## **Response to Planning application from Hertfordshire County Council (T and CP GDP Order 2015)**

District ref: 6/2023/1574/FULL  
HCC ref: WH/17726/2023  
HCC received: 1 August 2023  
Area manager: Manjinder Sehmi  
Case officer: Sarah Forty

2 Mulberry Mead Hatfield AL10 9EN

Formation of a drop kerb to the rear of the site, with the addition of 3 parking bays to provide additional parking for a C2 Childcare home

PROJECT STATUS	PRELIMINARY		
PROJECT	2 Mulberry Mead, Hatfield, AL10 9EN		
TITLE	PROPOSED PLANS		
CLIENT	Lina Chirandura		
DRAWN BY G.V.	CHECKED BY Z.C.	DATE 28.07.2023	SCALE (@A1) 1:50
DRAWING NUMBER	UK2201-TD-A-102		
PROJECT NUMBER	BUILDING CLASS	PHASE	REVISION
UK23054

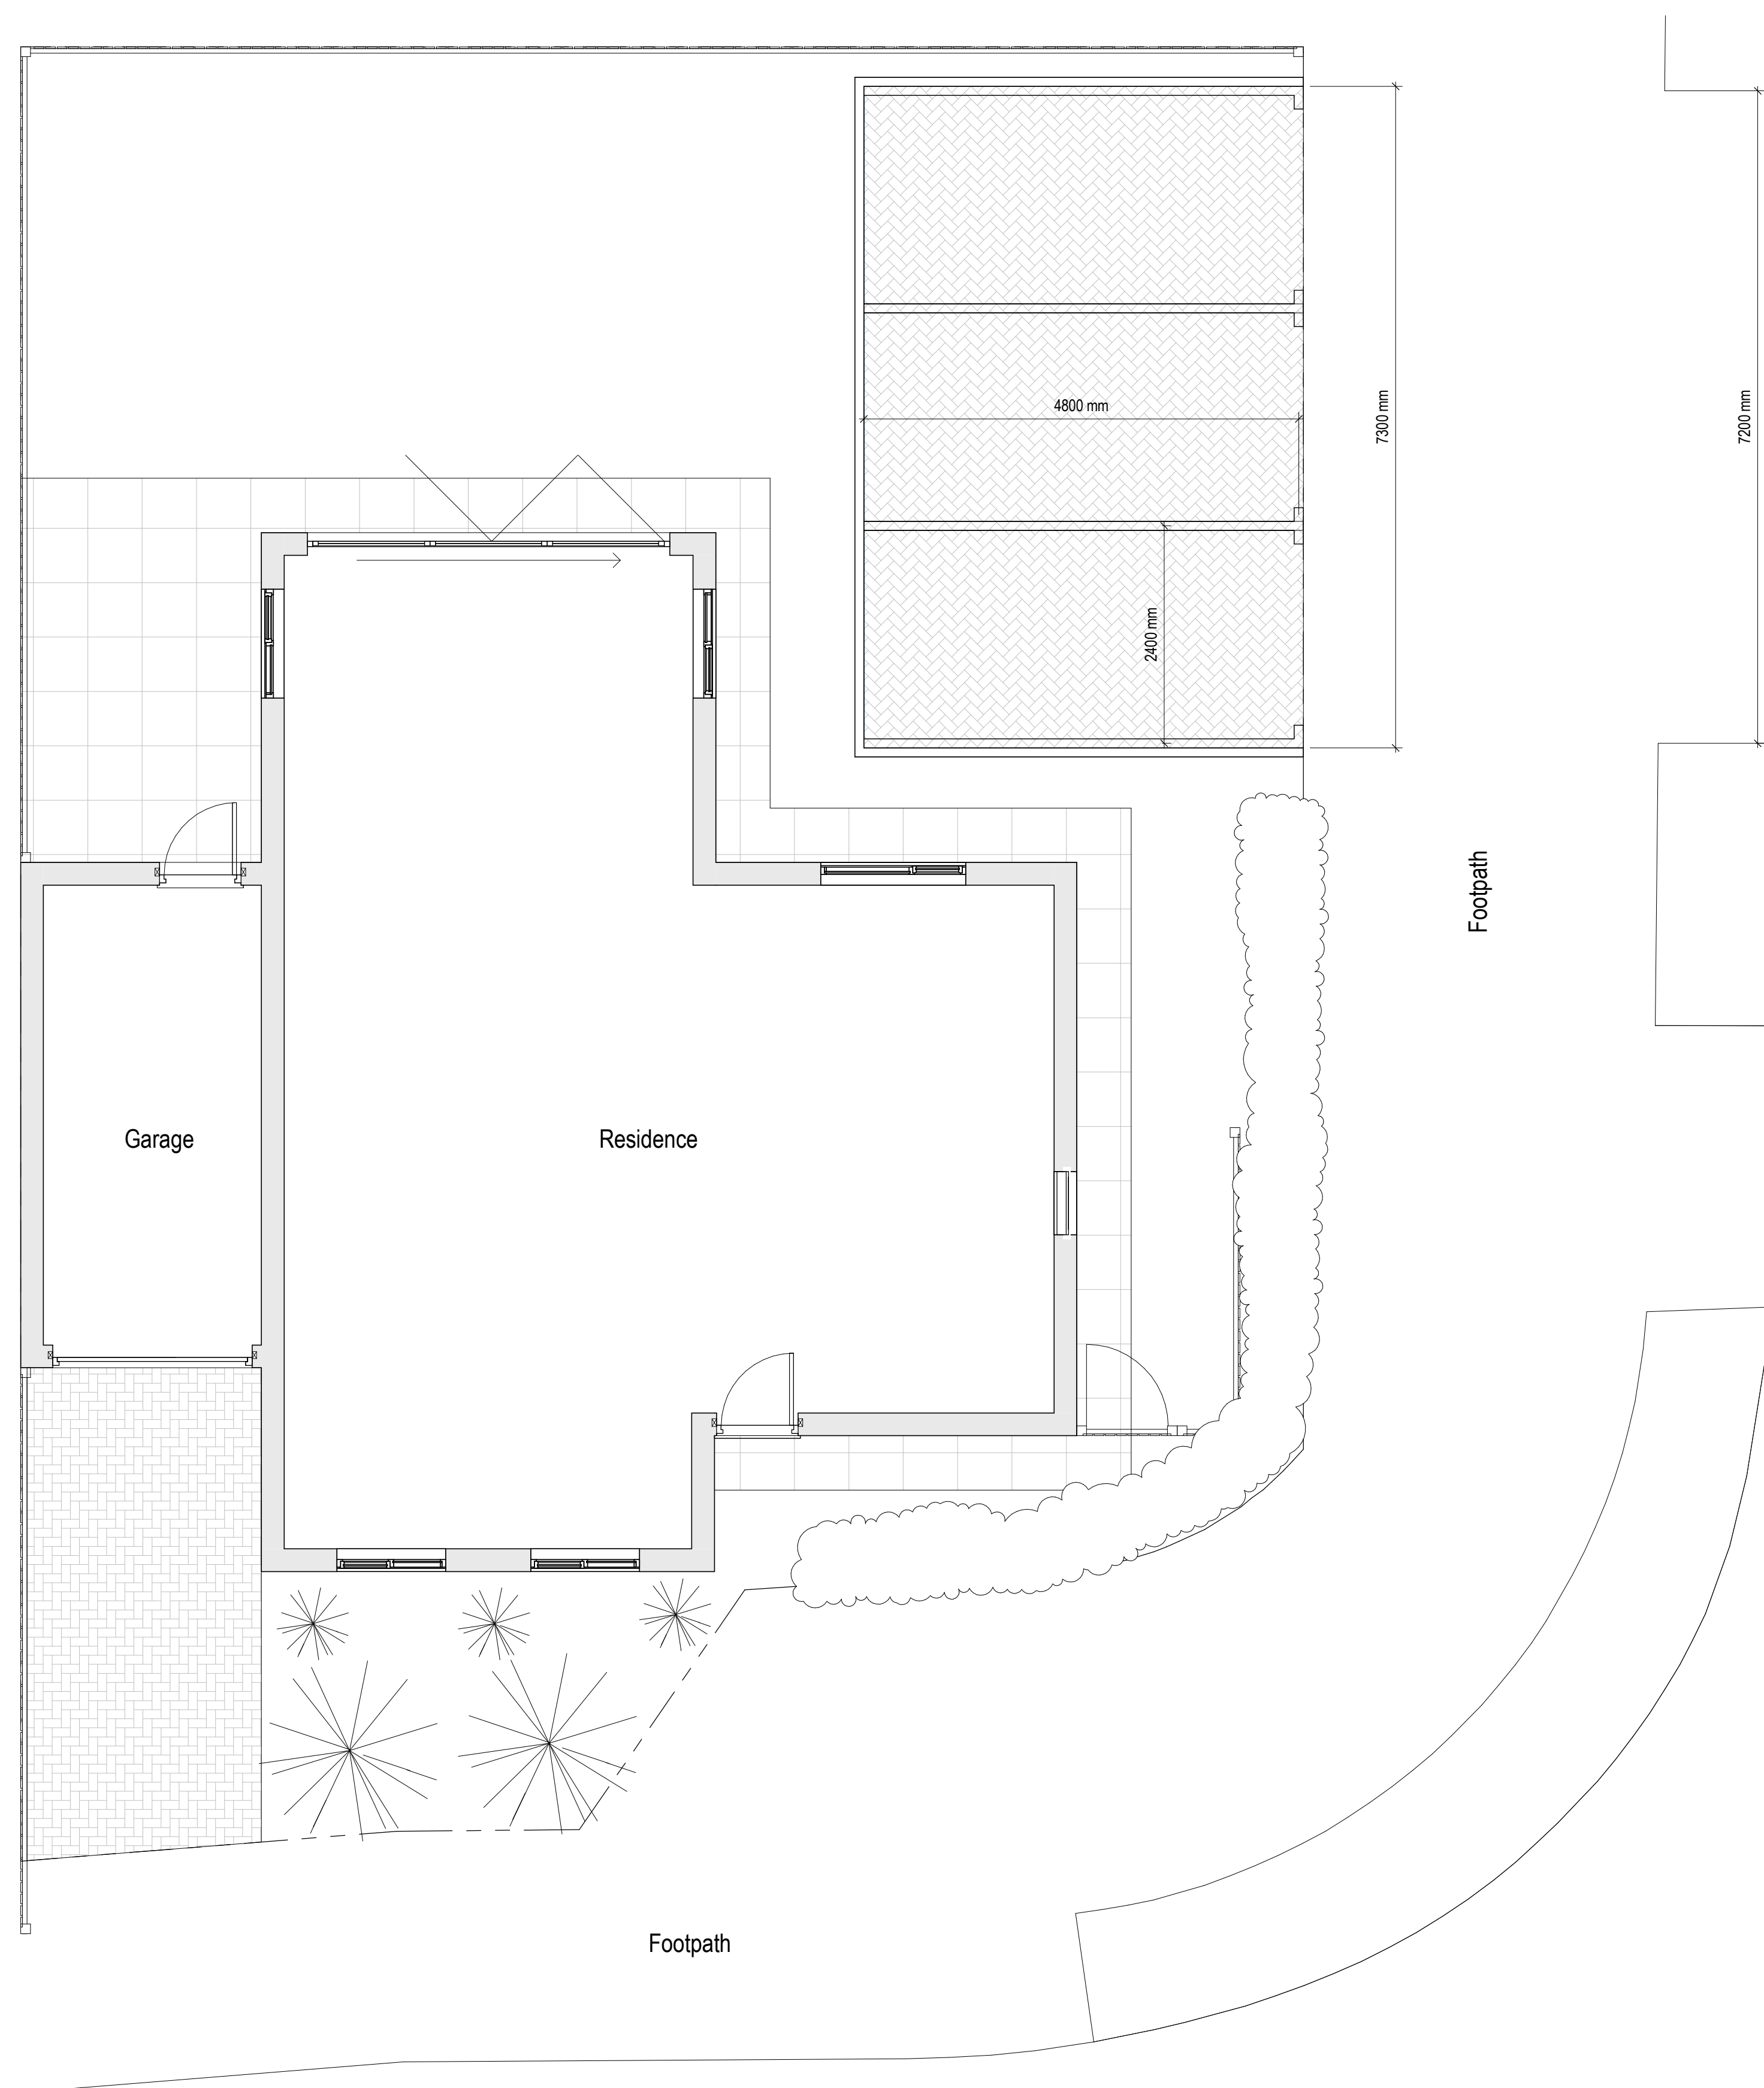
The proposed access arrangements are not in accordance with Hertfordshire County Council specifications as documented in Roads in Hertfordshire; Highway Design Guide and has the potential to interfere with the free and safe flow of highway users on the adjacent highway. The proposals are therefore contrary to policy guidelines as outlined in the National Planning Policy Framework (NPPF) and Hertfordshire Local Transport Plan (LTP4).

The application proposes to create a dropped kerb at the site to facilitate additional onsite parking. However, although not clearly shown on the proposed plans, there is already a dropped kerb at the site which serves the existing garage. In accordance with the Residential Dropped Kerbs Policy, secondary accesses are not acceptable as they are an additional area of conflict between highway users, giving priority to vehicles crossing the footway and interrupting the highway user hierarchy outlined in Policy 1 of LTP4. Additionally, the proposed dropped kerb would be considered oversized for use by a single house; a 7.2m dropped kerb would only be suitable when serving multiple dwellings as outlined in Roads in Hertfordshire. Drawing number UK2201-TD-A-102 shows the depth of the parking area to be 4.8m, whilst within the new Residential Dropped Kerbs Policy, the depth of a hardstanding must be a minimum of 5m to allow for a modern vehicle to park and not overhang the footway.
